Ask for:	Chris Spong
Telephone:	01832 742351
Planning Services	
Our Ref:	NE/21/01067/FUL
Your Ref:	PP-09927814
Date:	13 July 2021

Proposal : **Remodelling existing property with 2 Storey extension to west; Single storey extensions to east and south; Replacement front entrance gates and stone boundary wall; Swimming pool to rear. at Maystone House Gretton Road Harringworth Corby Northamptonshire NN17 3AD .**

I refer to the above application received on **7 July 2021** but have to advise you that it is **INVALID/INCOMPLETE**. In order to enable further progress to be made, please supply the following:

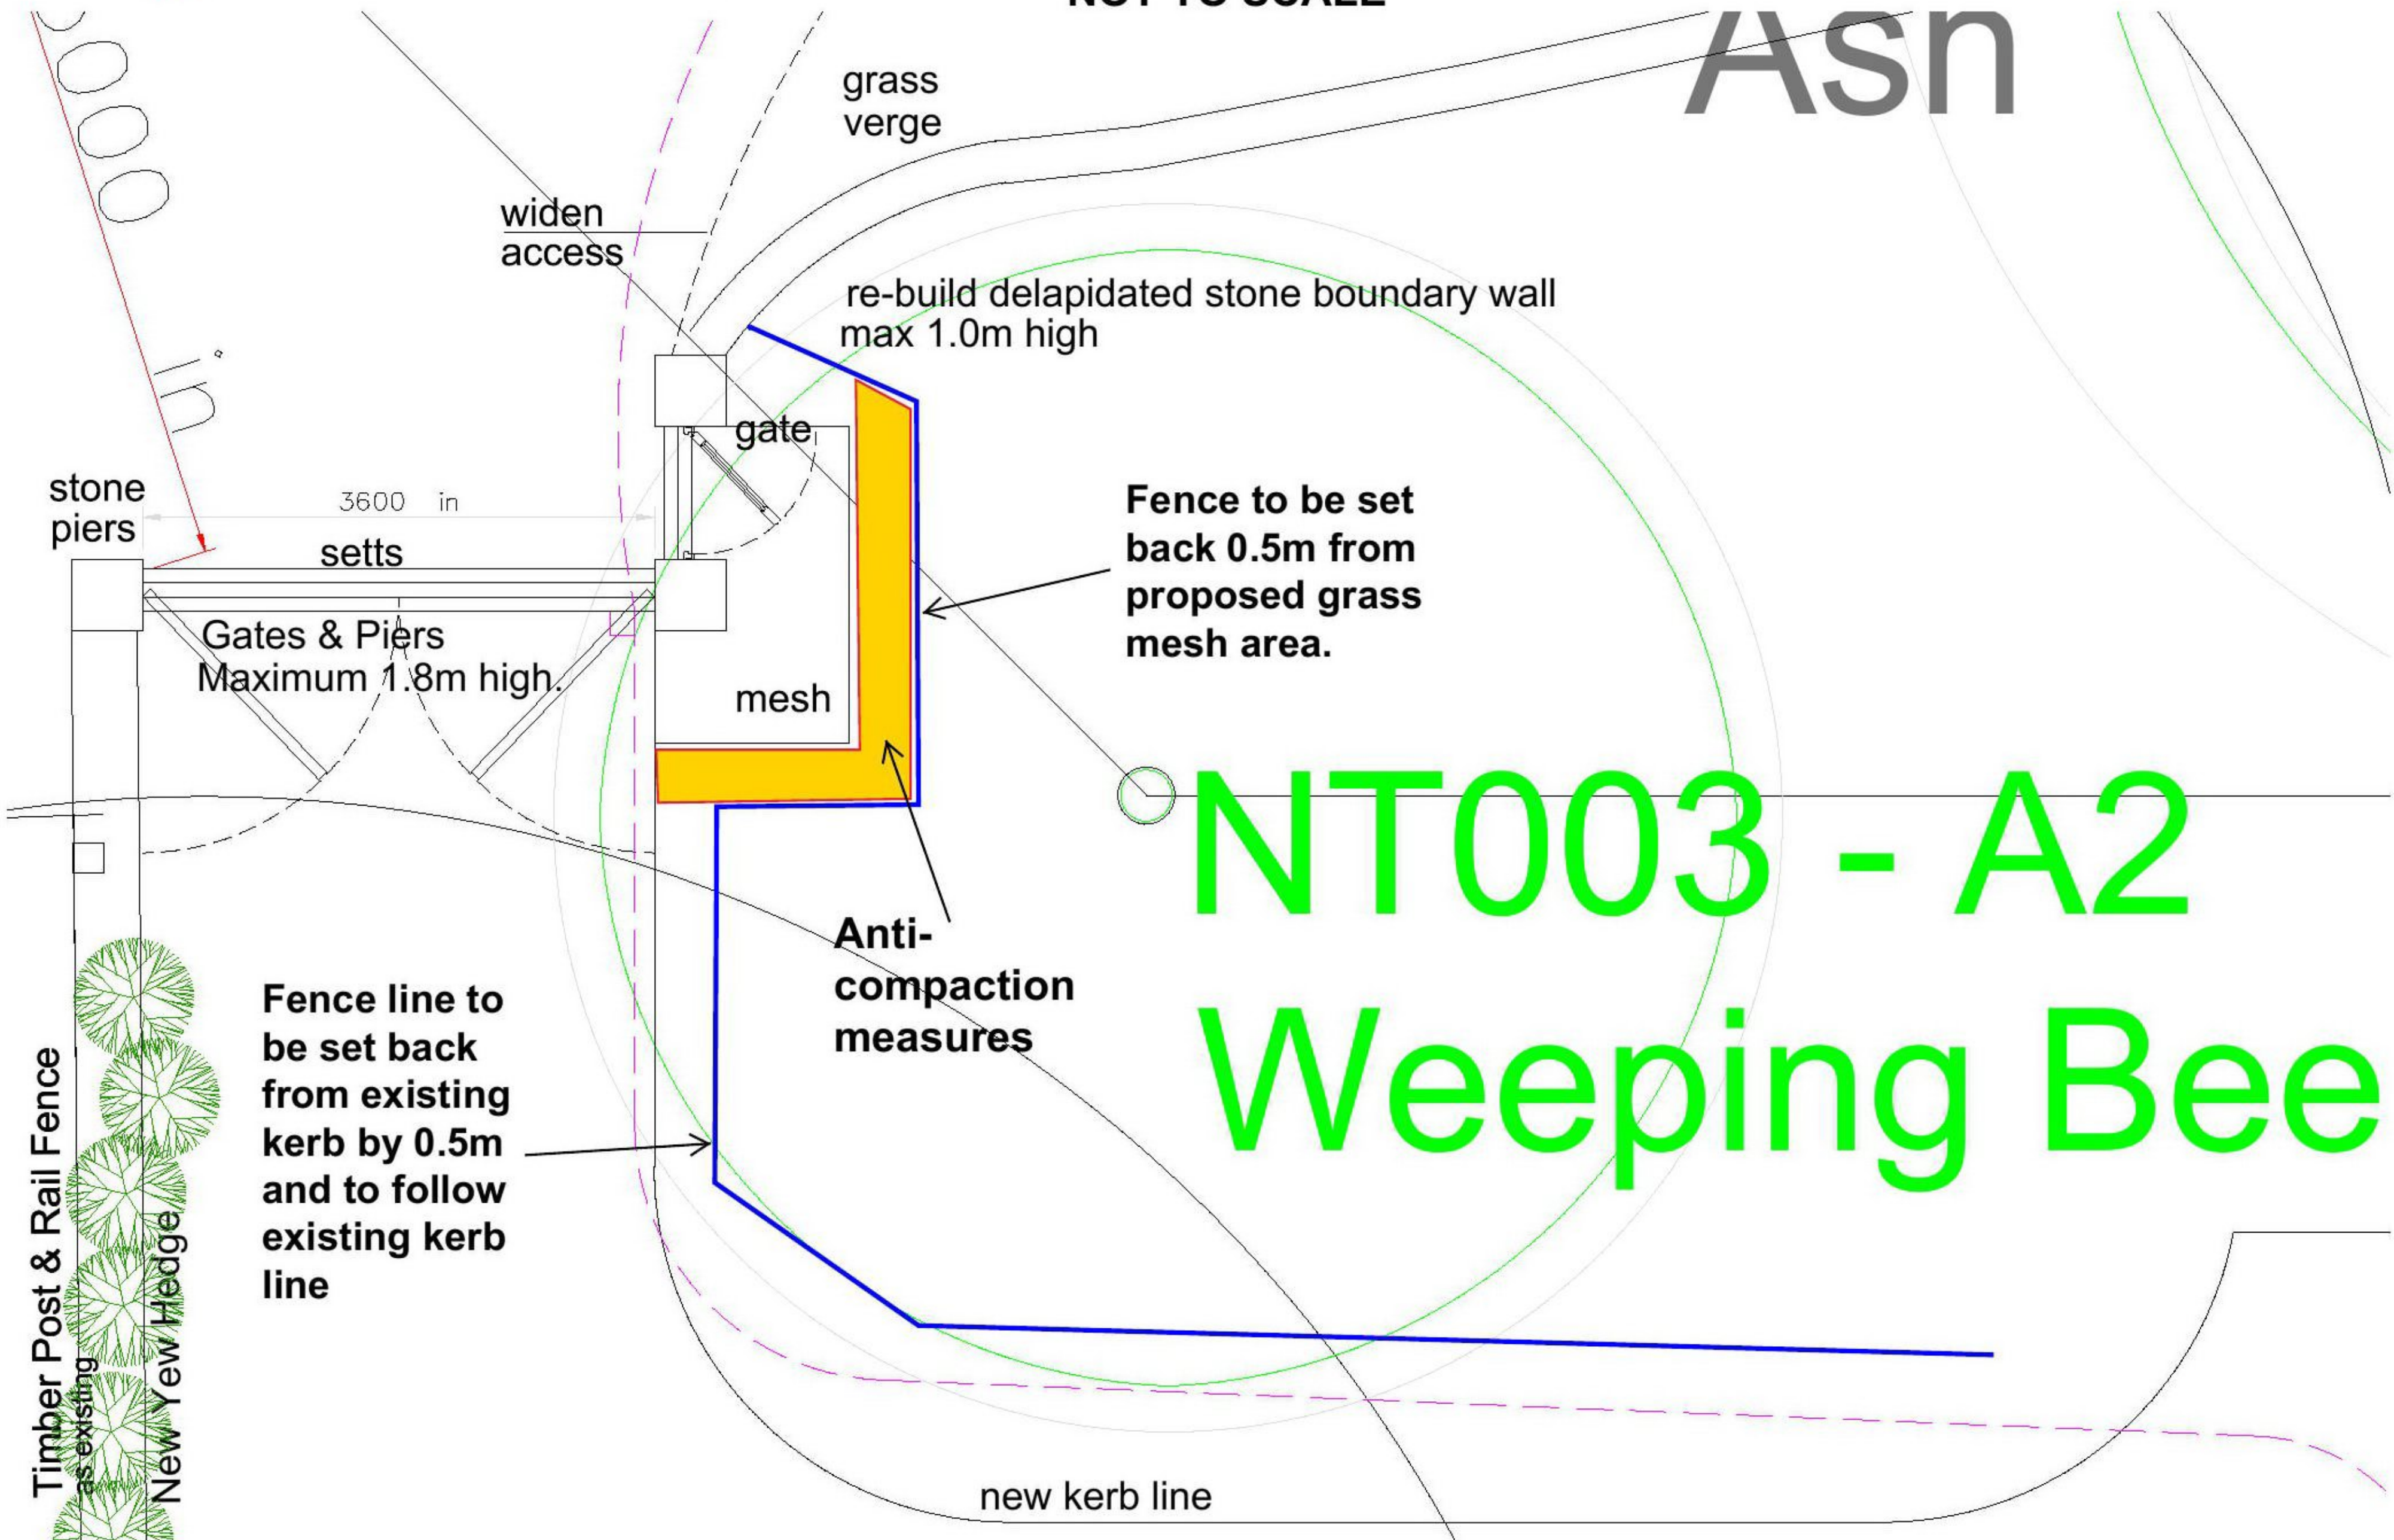
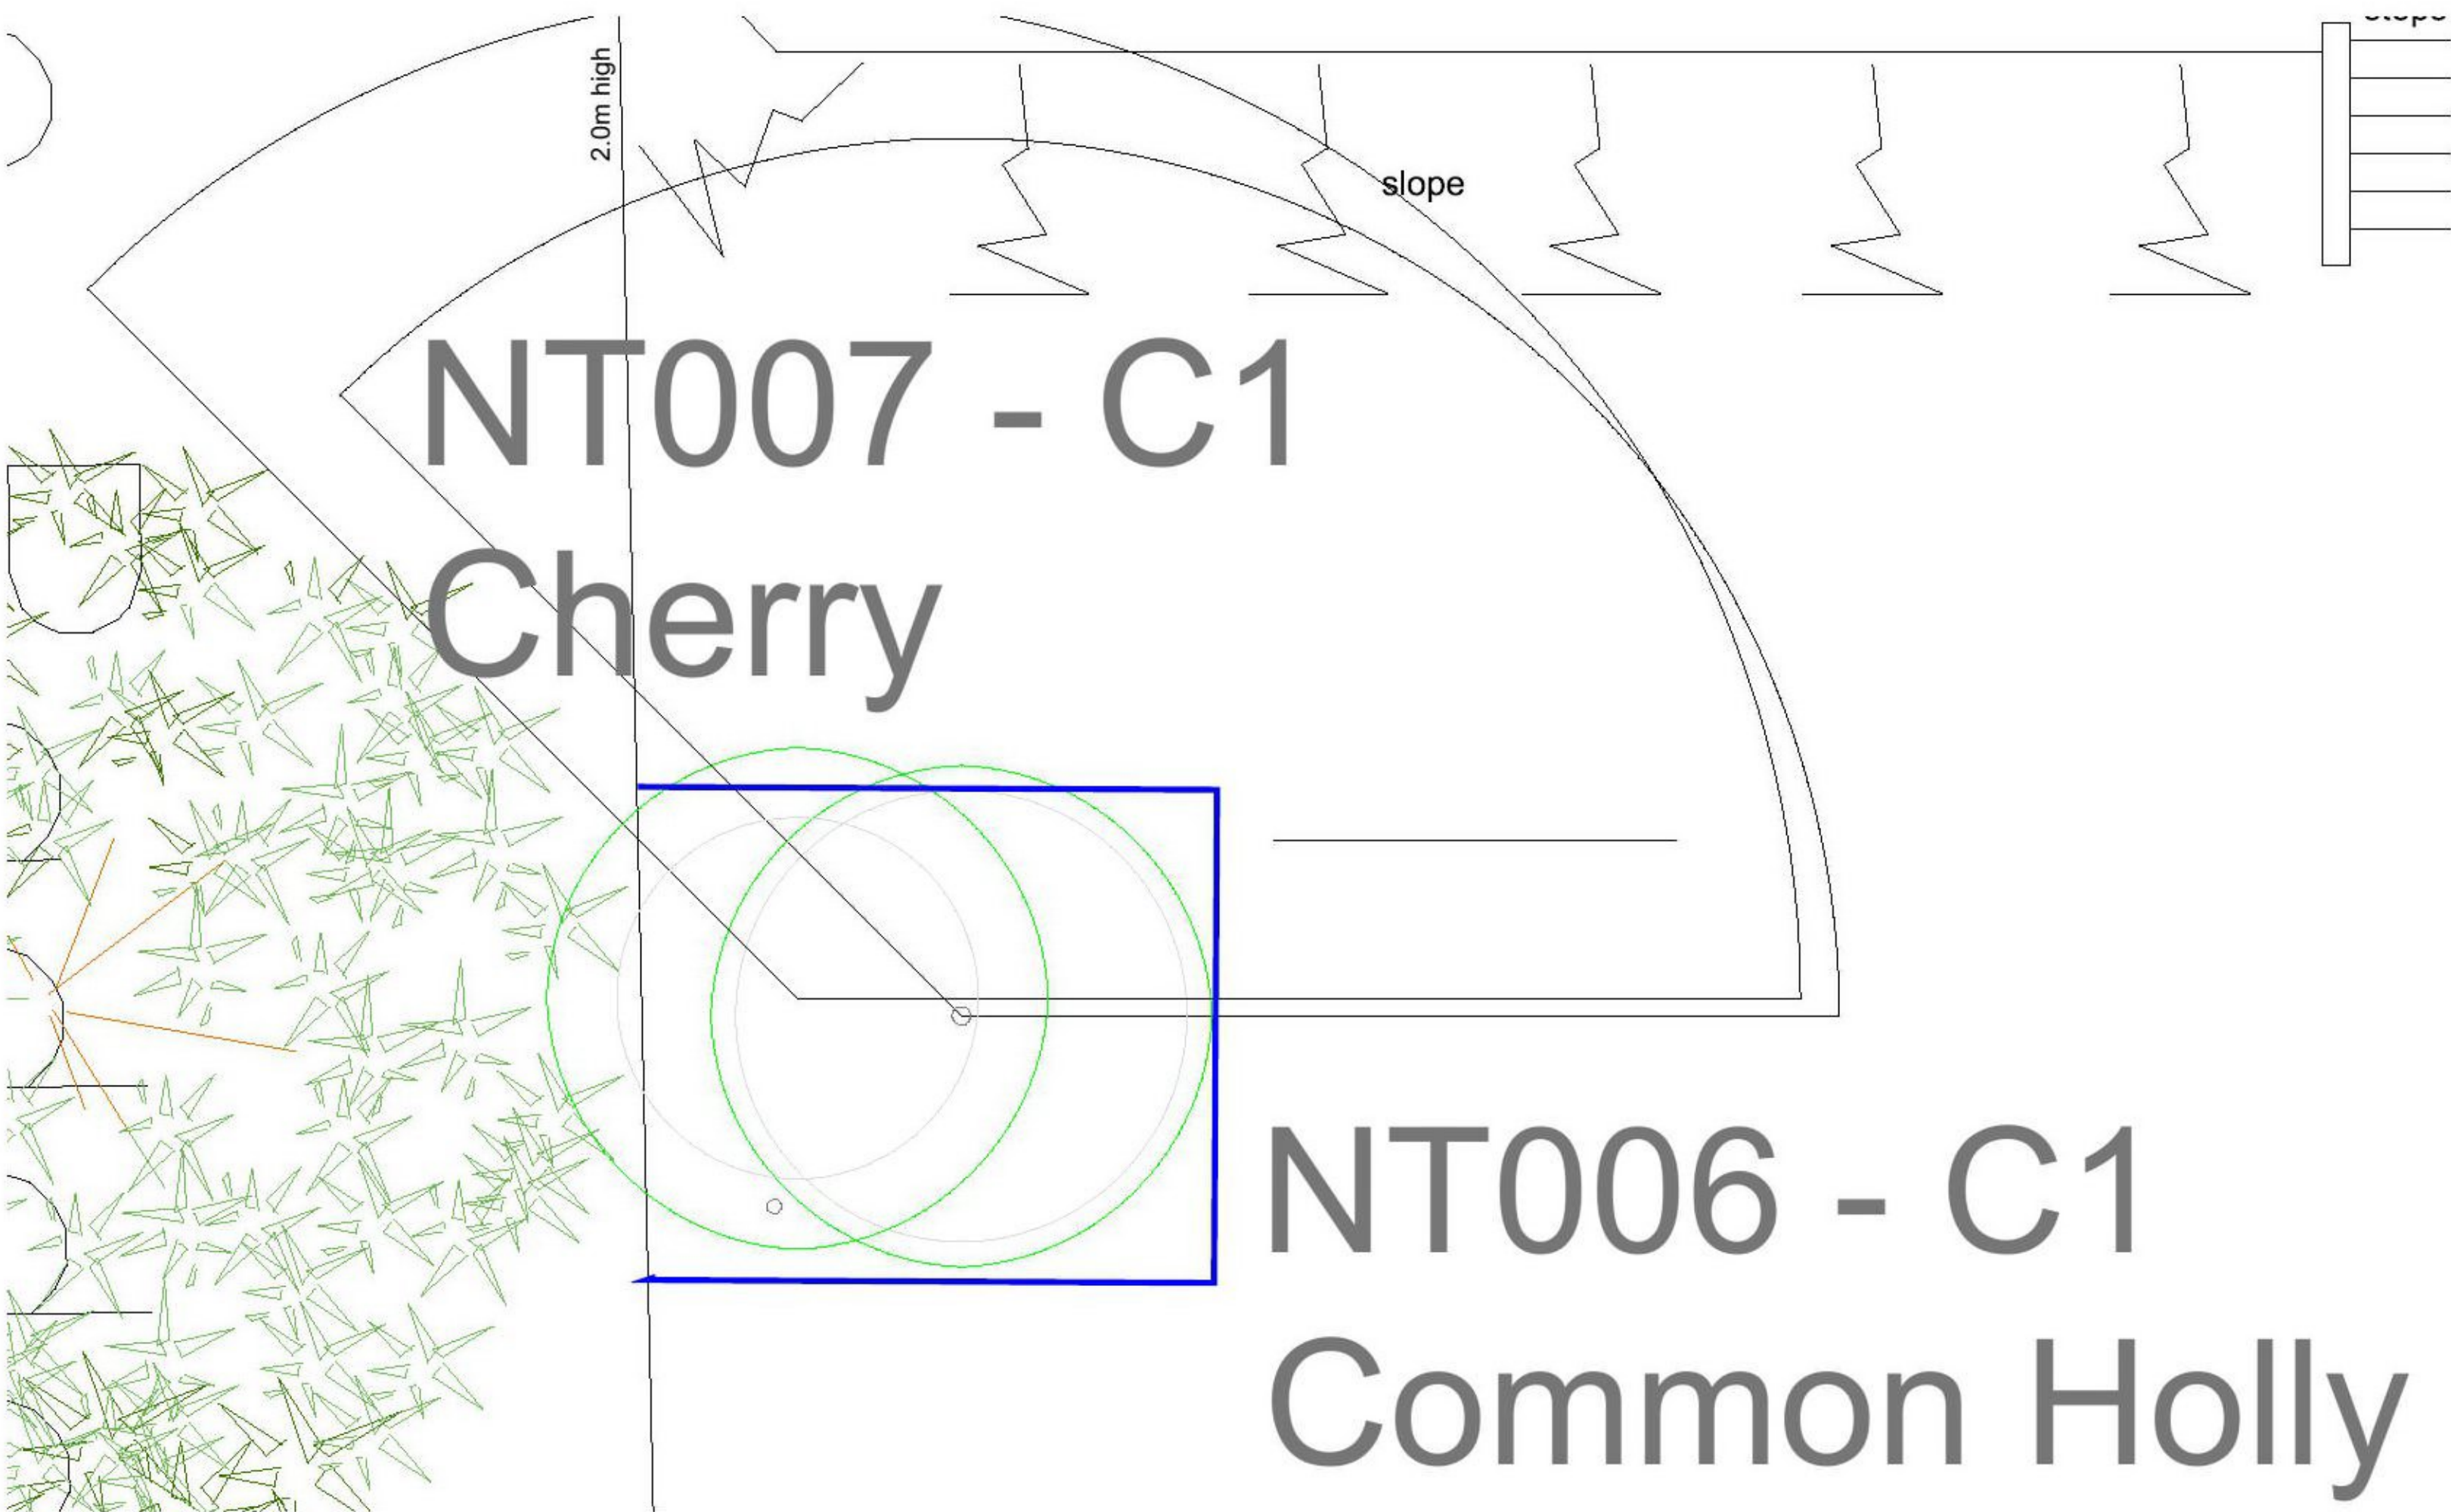
4. I note that the revised 'tree protection' / Heras fence drawing has been omitted from the supporting documents. Please submit the plan if it is still relevant to the proposal.
5. Please provide sections of the proposed swimming pool
